Ribble Valley Borough Council
Council Offices
Church Walk,
Clitheroe
Lancashire
BB7 2RA

Phone: 0300 123 6780
Email: developer@lancashire.gov.uk
Your ref: 3/2026/0530
Our ref: 3/2026/0530/HDC/KW
Date: 02 September 2026

Location: The Pentre Pendle Road Clitheroe BB7 1JQ
Proposal: Proposed rear and side extension, attached double garage with roof space storage and external works including new principal access drive from Goosebutts Lane.
Grid Ref: 374987 441335

7336 -S02 J

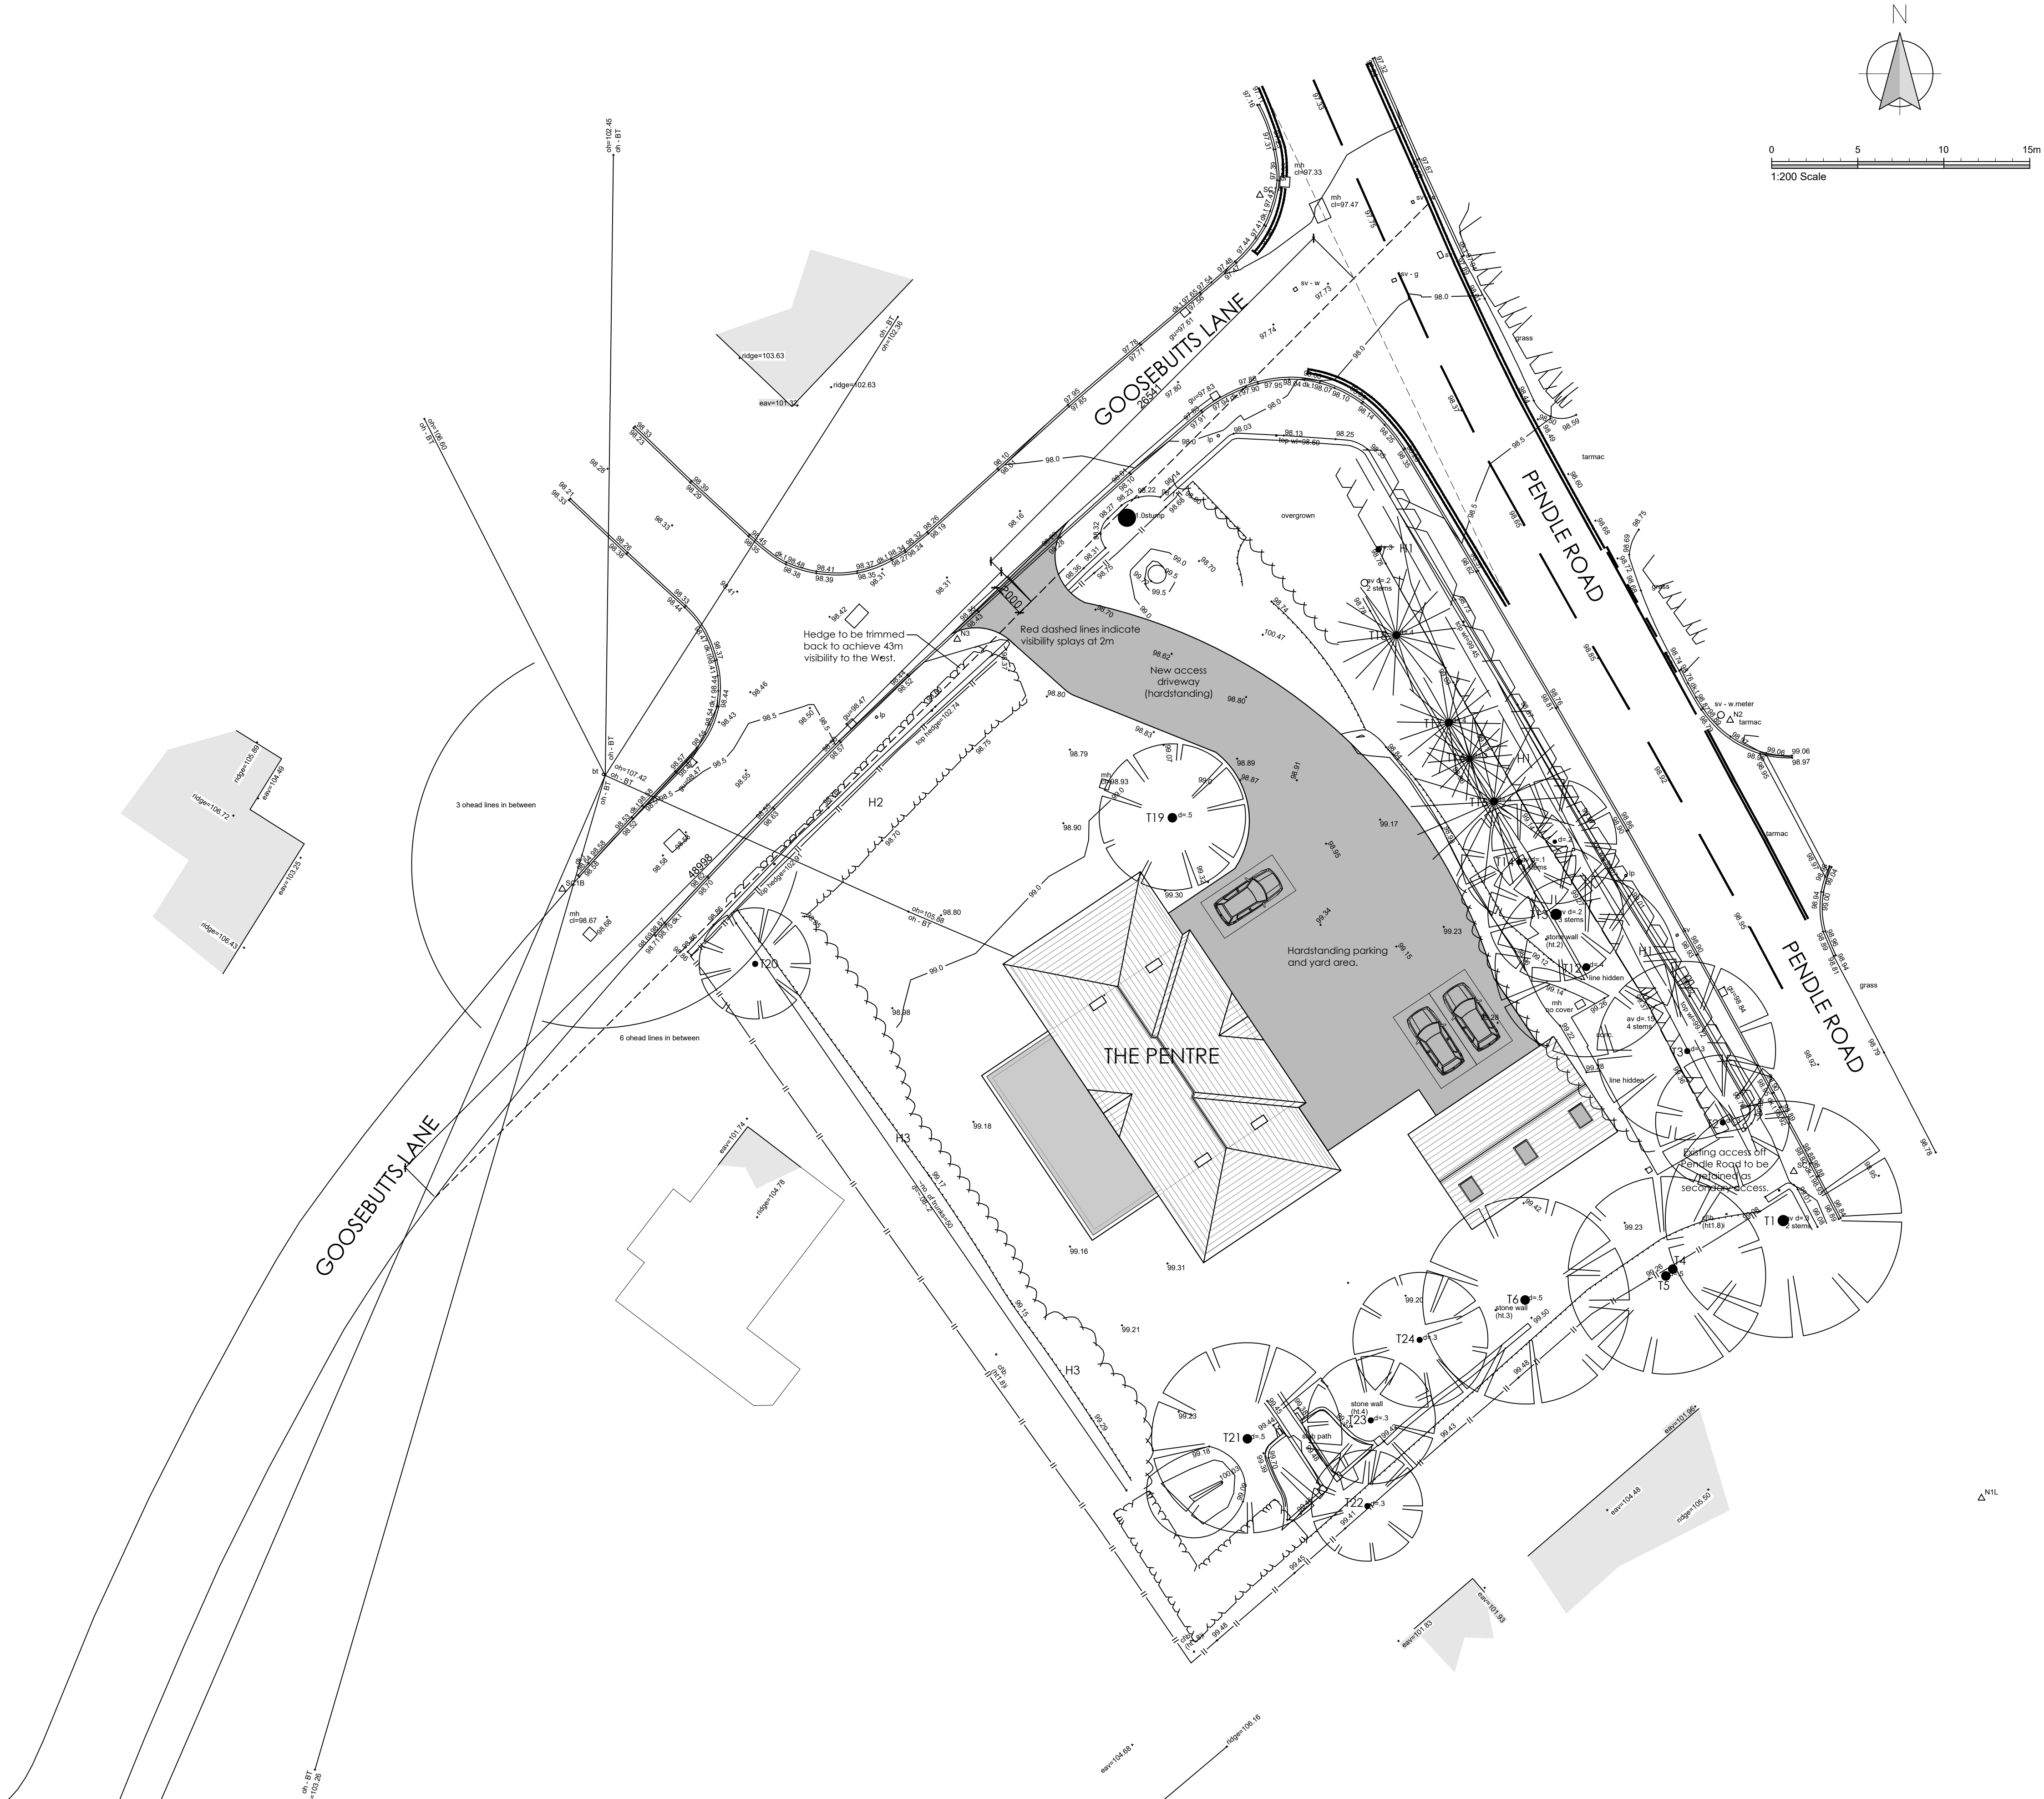
The LHA has reviewed the proposed site plan, drawing number 7336 S02F and understands that the new access will be appropriately 4.5m wide. The drawing also includes visibility splays for the proposed access points set 2 metres back from the near edge of the carriageway and extending 43 metres to the South and 26 metres to the North, providing acceptable visibility splays.

The visibility splay should be wholly within the land which the applicant controls and/or the adopted highway and nothing shall be erected, retained, planted and / or allowed to grow at or above a height of 0.9 metres above the nearside carriageway level which would obstruct the visibility splay of the proposed access.

The access shall be appropriately paved in a hardstanding material from the back of the footway for the first 5m into the site and a new vehicle crossing within the adopted highway will need to be constructed under a section 171 agreement of the Highways Act 1980.

Whilst works to widen the access take place, the applicant shall include surface water drainage at the access point, which should be drained into an internal outfall.

The LHA are aware that the dwelling complies with the LHAs parking standards as defined in the Joint Lancashire Structure Plan. There are also turning provisions within the site to allow for ingress and egress in a forward gear.

2. No part of the development hereby permitted shall be occupied until such time as the access arrangements shown on drawing number 7336 S02F have been implemented in full.

3. No building shall be occupied until visibility splays 2 metres back from the centre line of the access and extending 43 metres to the South and 26 metres to the North along the nearside carriageway edge have been provided at the access, as shown on the approved plans. Nothing shall be erected, retained, planted and / or allowed to grow at or above a height of 0.9 metres above the nearside carriageway level which would obstruct the visibility splay. The visibility splays shall be maintained free of obstruction at all times thereafter for the lifetime of the development.
